Tel: 01903 737756
Email: planning@arun.gov.uk
www.arun.gov.uk/planning
Please ask for: Mrs D Johnson
Email: daun.johnson@arun.gov.uk
Telephone: 01903 737762
Our Ref: FP/55/26/PL
Your Ref:
Date: 29th May 2026

Application for Planning Permission

Development: Demolition of garage and conservatory, extension and alteration of existing bungalow to create two separate dwellings including a new crossover to public highway.

Location: 6 Ormesby Crescent Felpham PO22 8EN

Proposed Extension and New Dwelling
at 6 Ormesby Crescent, Felpham
for Mr J Bryant & Mr S Bryant
Drawing P01a June 2025 Scale 1:100 @ A3
Planning Drawing - Proposed Floor Plan & Elevations

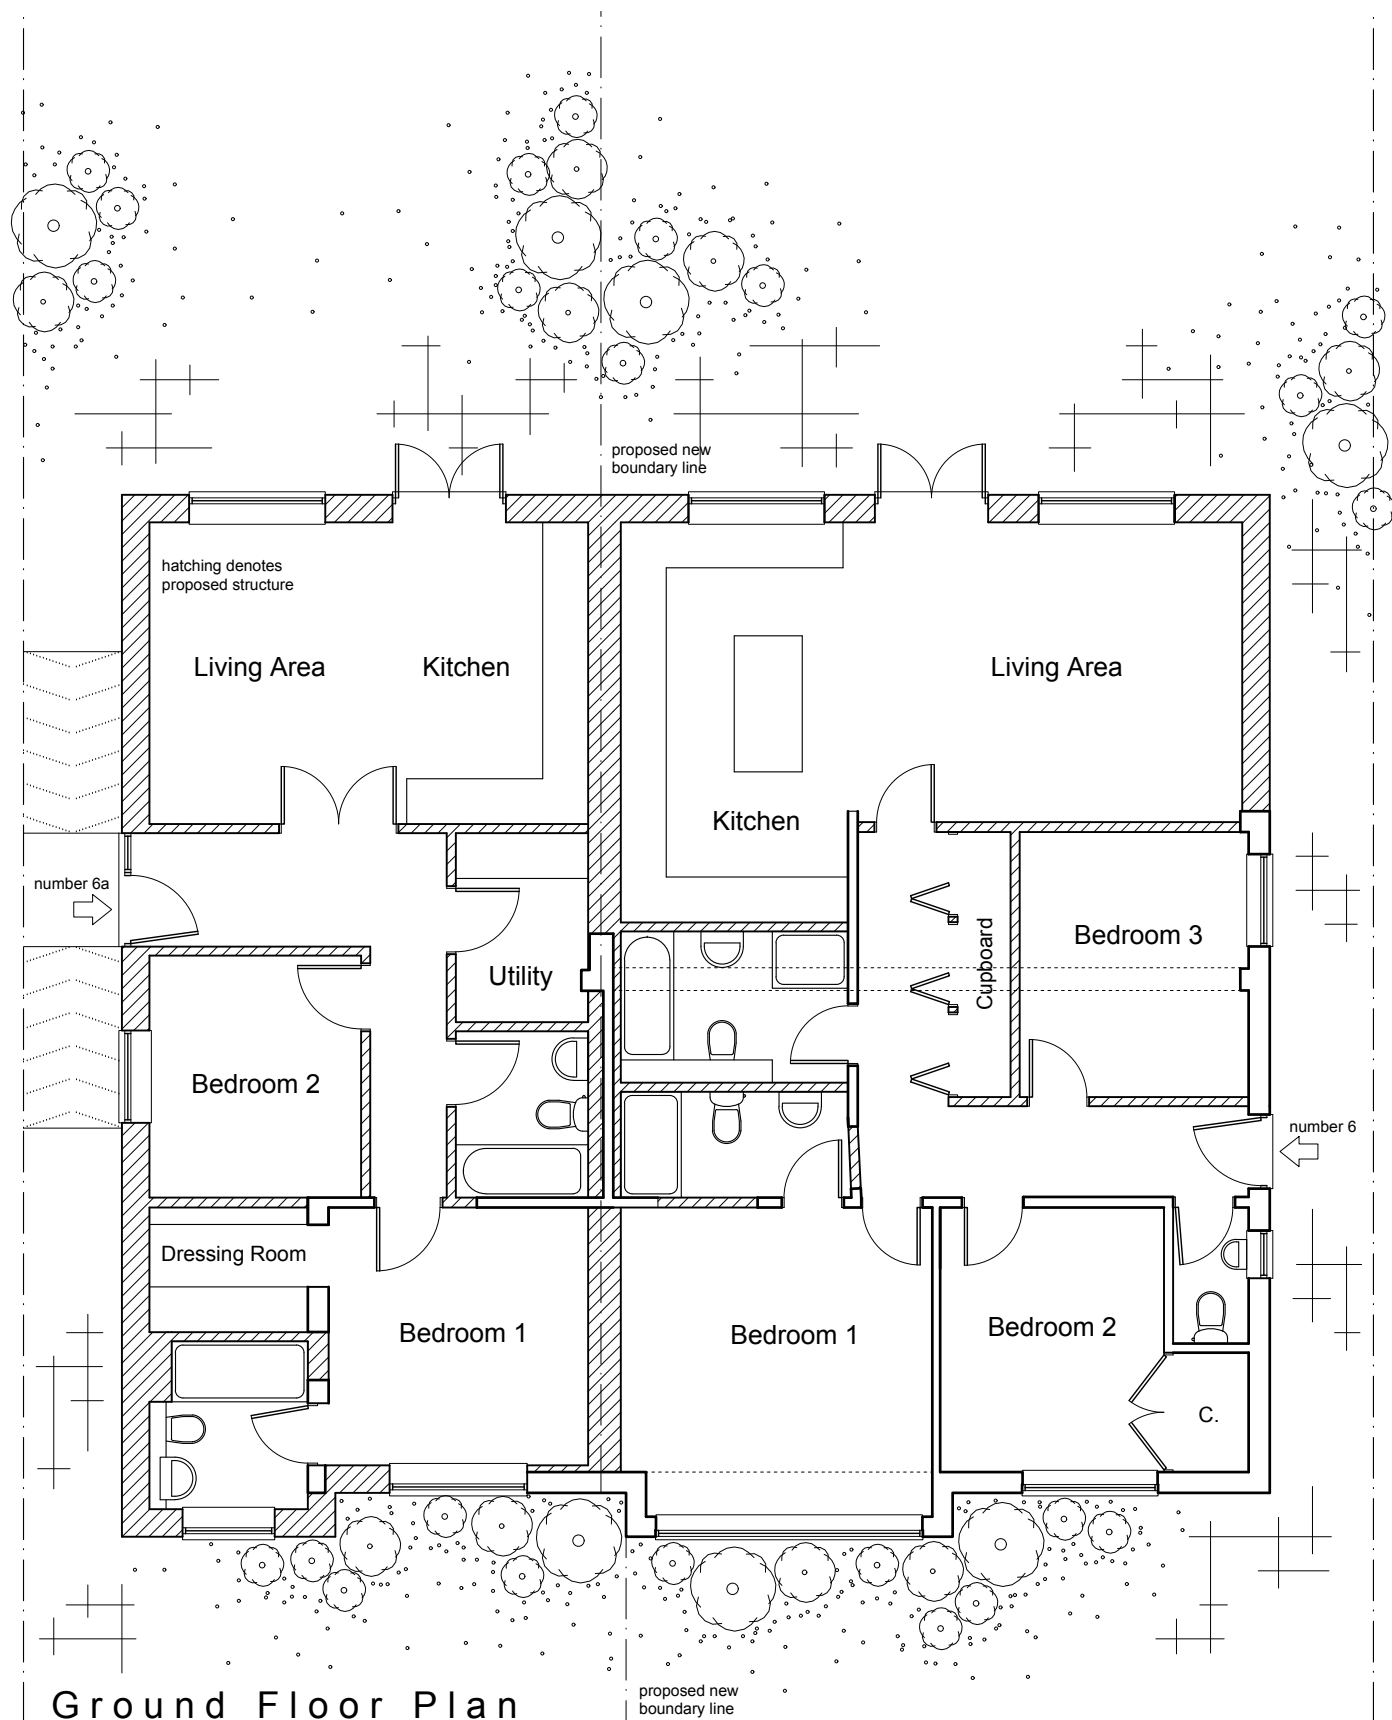
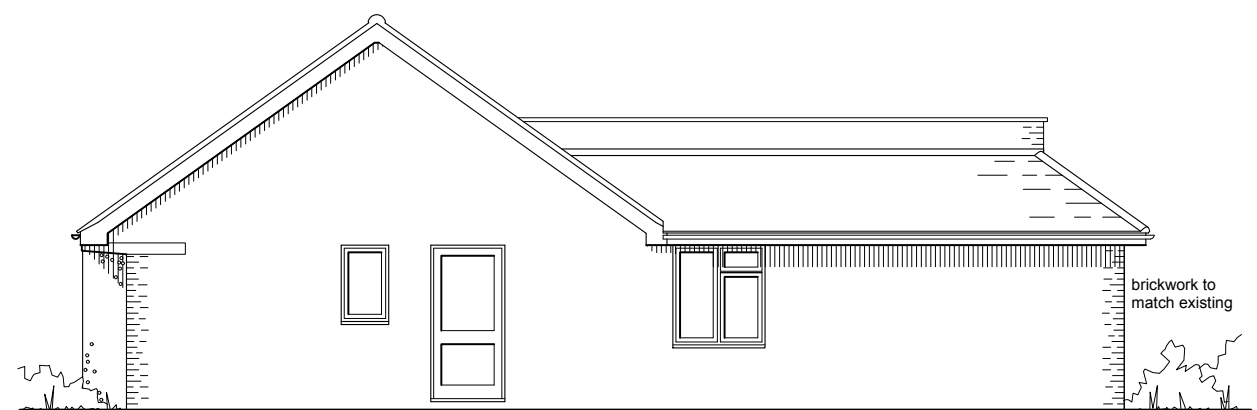
The proposed floor plan and south elevation do not accord. The WC window is in the incorrect position. Please amend accordingly.
